**RESPONSE TO THE DEPARTMENT'S RESPONSE TO SUBMISSIONS
ELIZABETH DRIVE SUBDIVISION (SSD 8859)**

Ae Design Partnership has prepared this letter on behalf of Elizabeth Drive Pty Ltd ("**the Applicant**") in response to the Department's Request for Response to Submissions letter dated 15 April 2019 (**Attachment 1**) in relation to the State Significant Development 8859 ("**SSD 8859**") application on the property legally identified as Lot 2 Section 4 DP 2954, otherwise known as No. 1111-1116 Elizabeth Drive, Cecil Park ("**the site**")

TITLE  
EARTHWORKS CUT-FILL PLAN

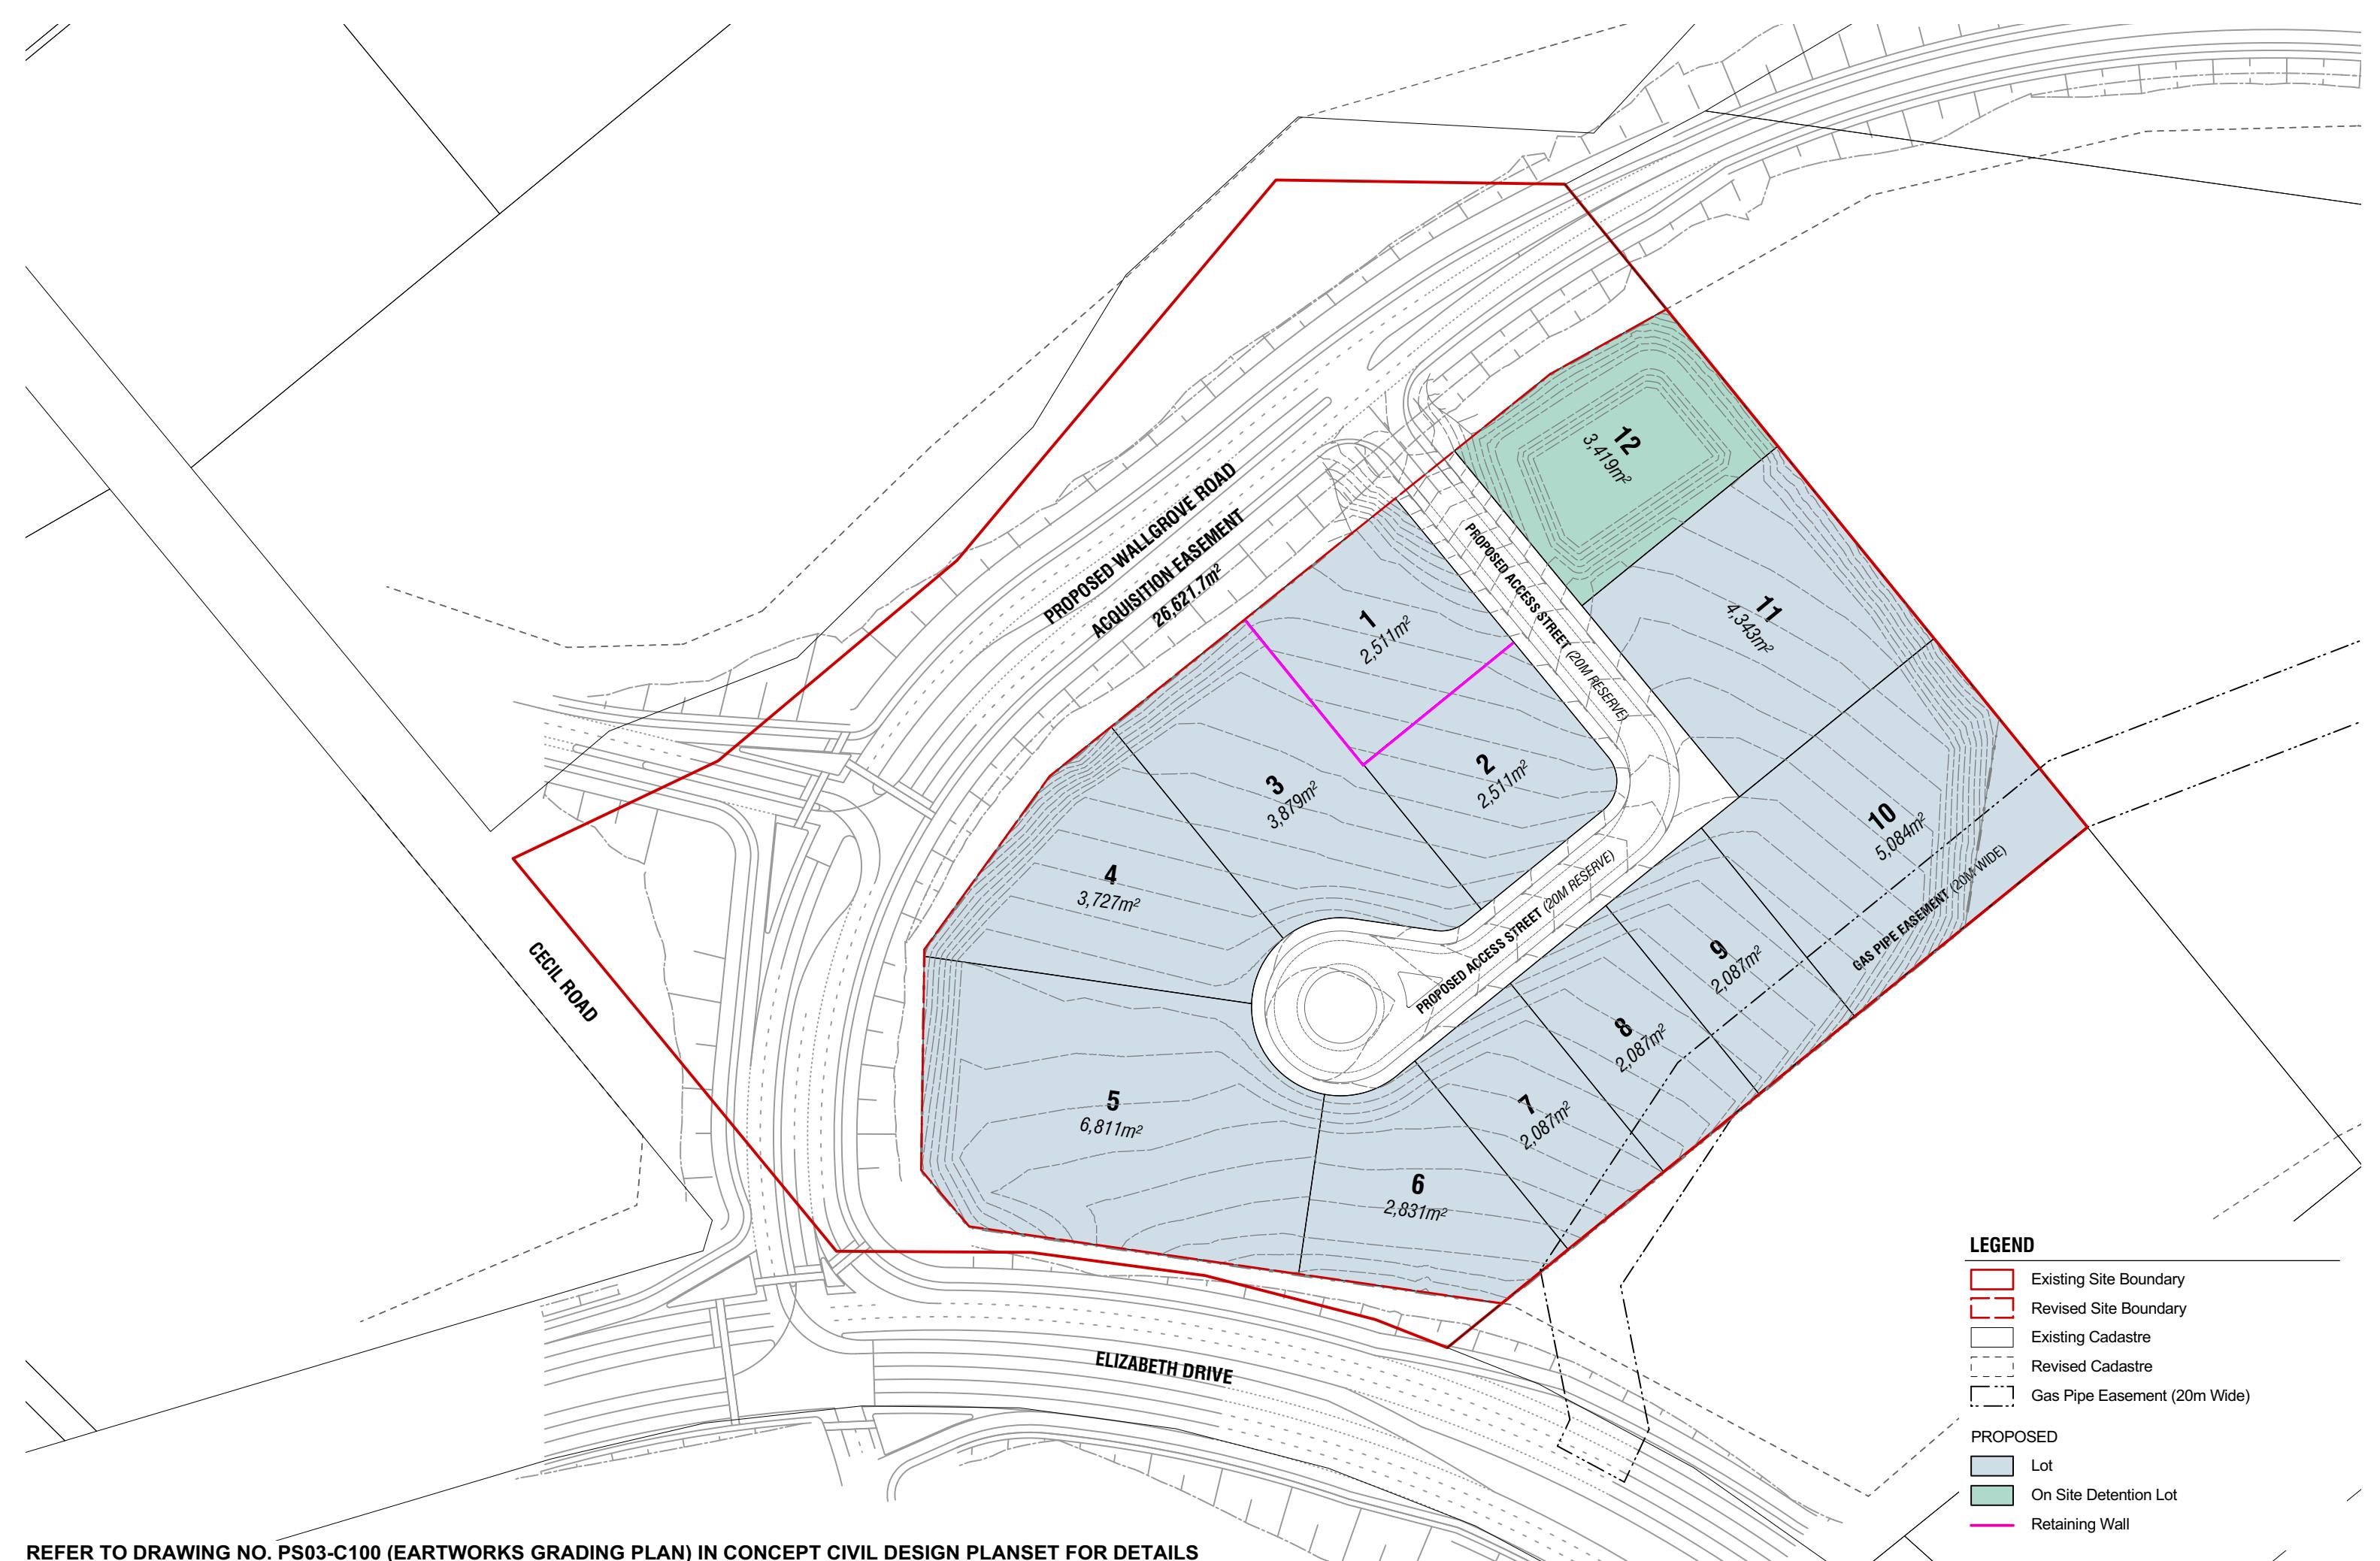
b. Sectional plans c. Retaining wall design.	
25. Provide a detailed plan showing all cut and fill proposed on site.	Revised Civil Design Plans detailing all cut and fill proposed on the site is provided on Drawing Sheet PS03-C500 at Attachment G.
Visual Impacts	
26. Provide an assessment of the potential visual impacts of the proposal from the nearest residential dwelling to the north, including photomontages.	Photomontages are no longer required due to new Wallgrove Road alignment that will be undertaken by Transport for NSW between neighbouring residential properties and the site.
